Erection of a two storey rear extension, second storey enlargement of side dormer and conversion of garage to study including demolition of existing conservatory
100 Sea Road East Preston

Thank you for your internet representation made on 20th December 2018 which has been recorded as '**an objection**' with the comments as follows:

I am commenting on this application on behalf of the East Preston and Kingston Preservation Society.

PROPOSED ELEVATIONS 1:100

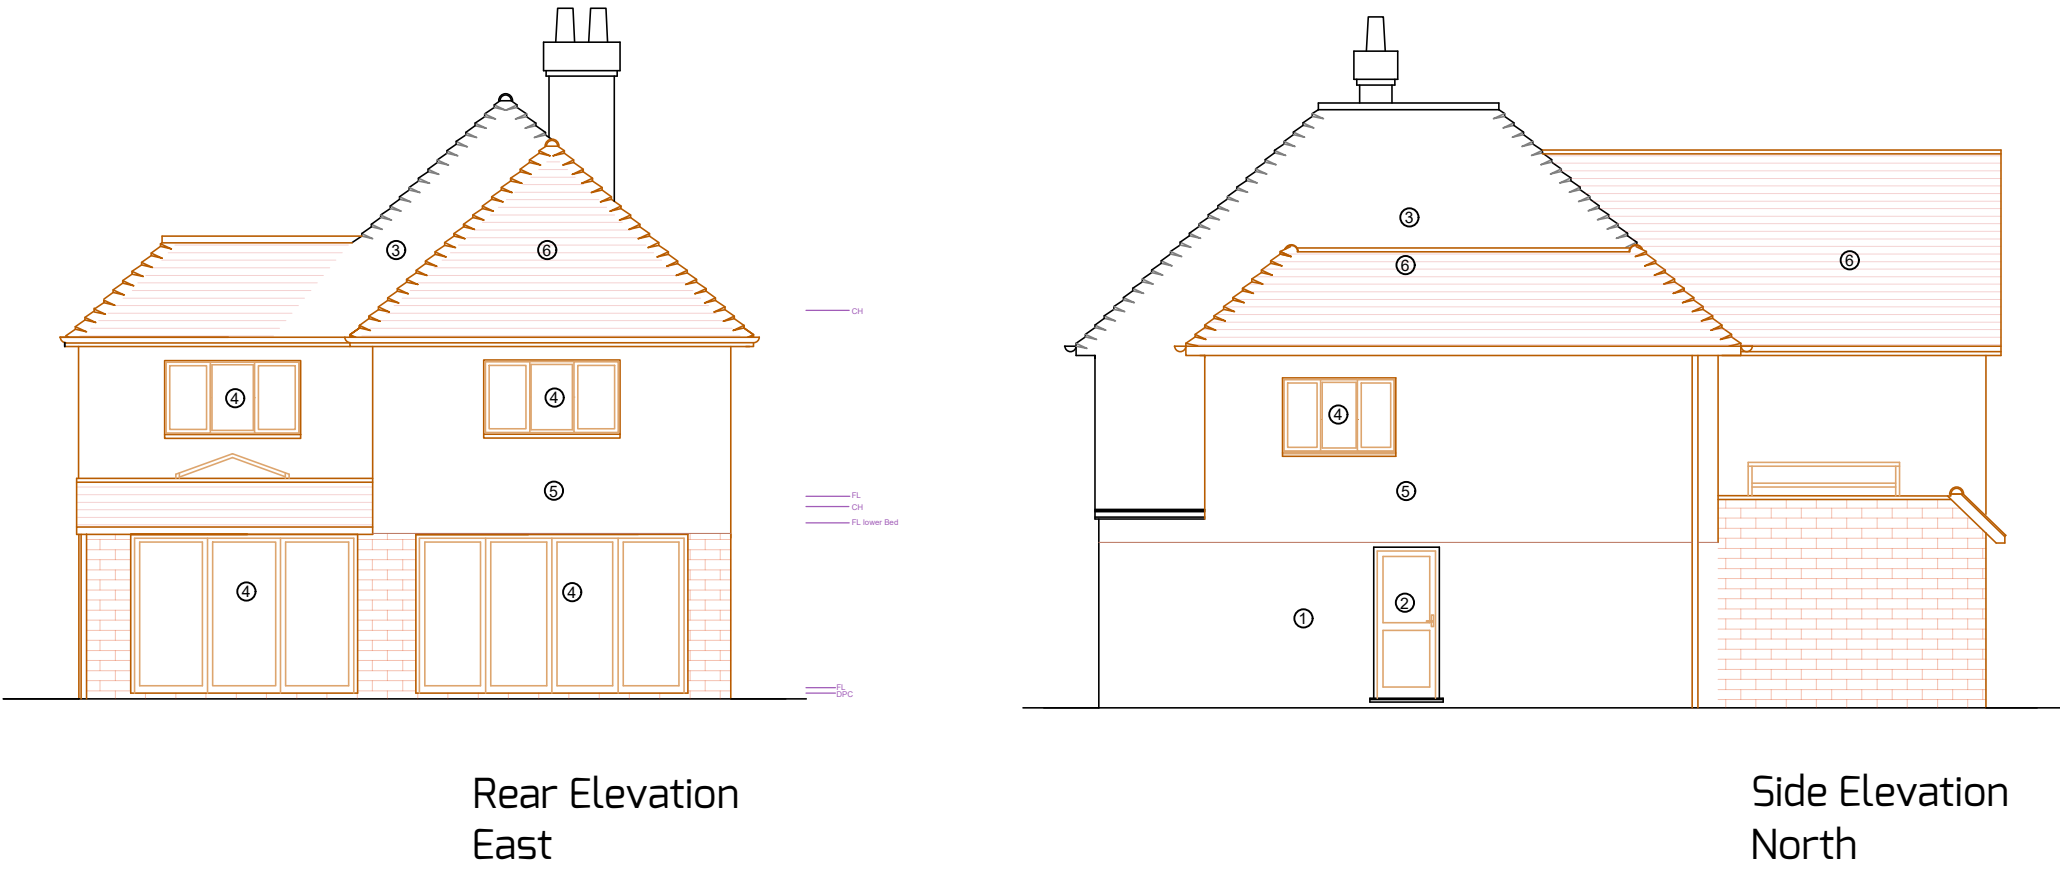
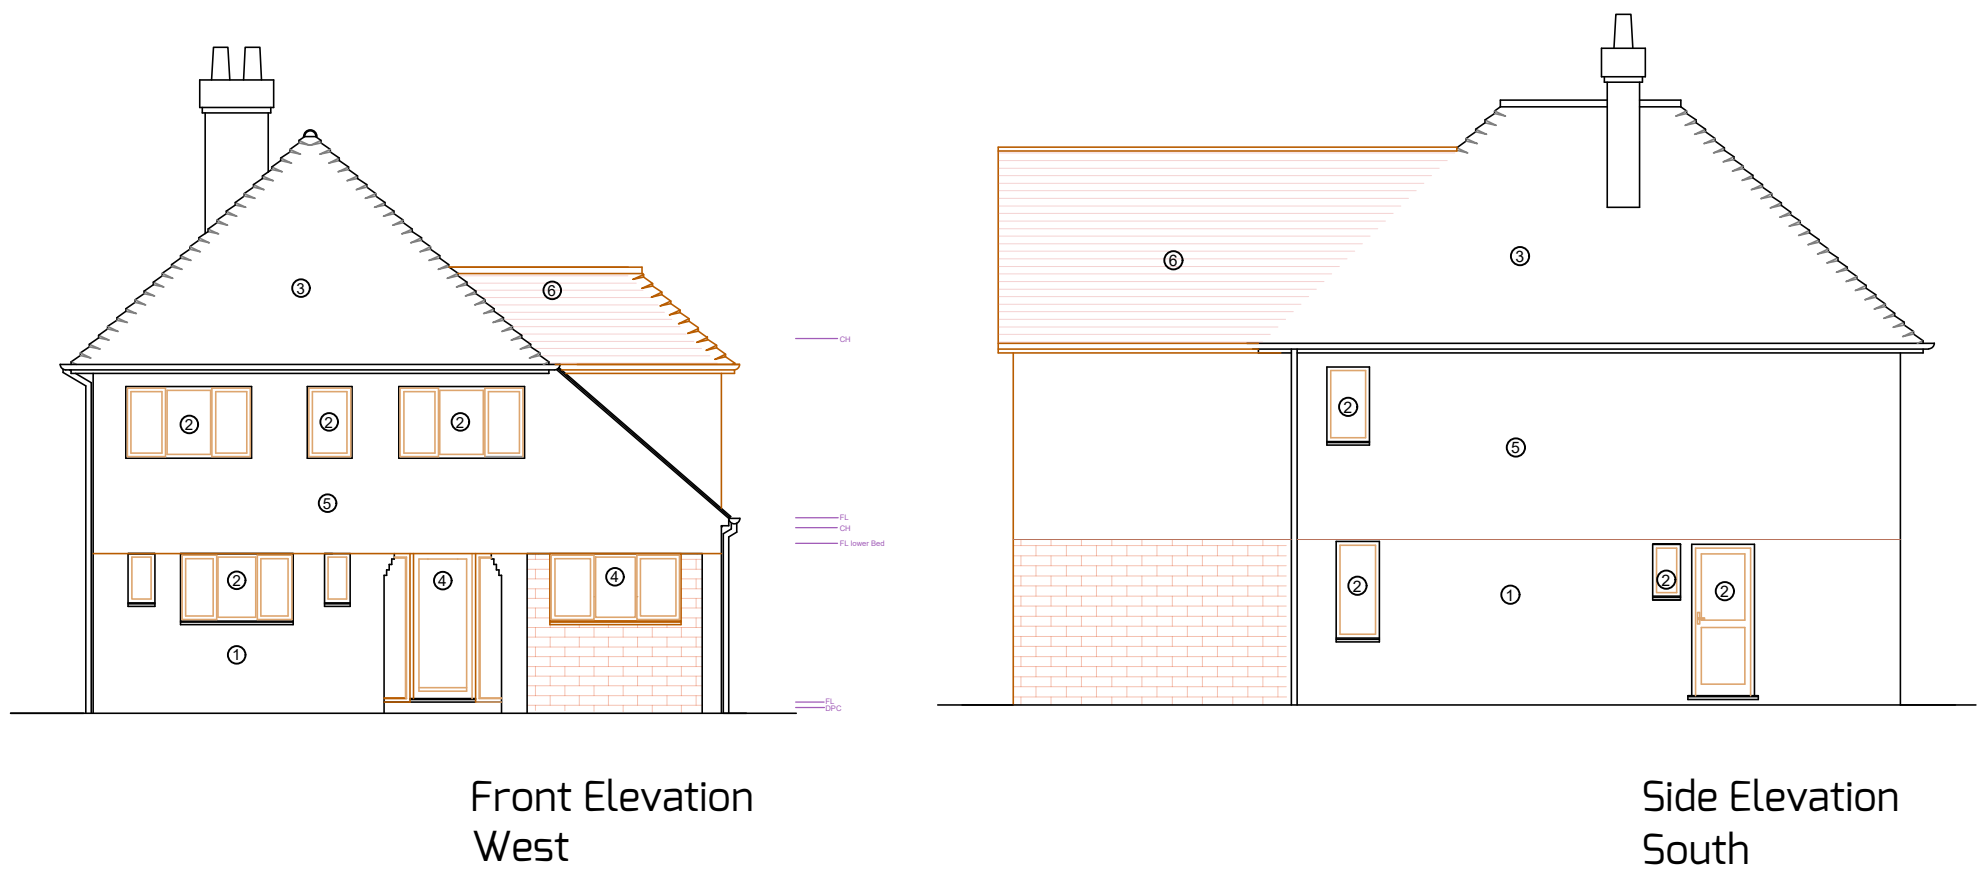
We object to the proposed alterations to 100 Sea Road because the changes to the street facade would do serious harm to the appearance of Sea Road, while the two storey extension at the rear would harm the amenities of neighbouring properties.

The houses on the west side of Sea Road are of similar design but with some variations in materials, either decorative brickwork - as on 100 - or half timbering, but all possessing an essentially Arts and Crafts style. Their uniform and attractive appearance makes a valuable contribution to the appearance of the village, opposite the village green, on the road that leads to the sea. The alterations would replace the decorative brickwork and exposed beam with plain render. No other house in the row has such a facade. The appearance of the house would therefore conflict with that of its neighbours and would harm the present architectural interest and appearance of the road. An architectural character that has been preserved for more than 100 years would be lost. The alterations would therefore contravene Policies 1 and 2 of the East Preston Neighbourhood Plan, because they would not reflect the architectural and historic character of the surrounding buildings, and because they would not preserve the street scene. The alterations would also conflict with para. 127(c) of the NPPF, because they are not sympathetic to local character.
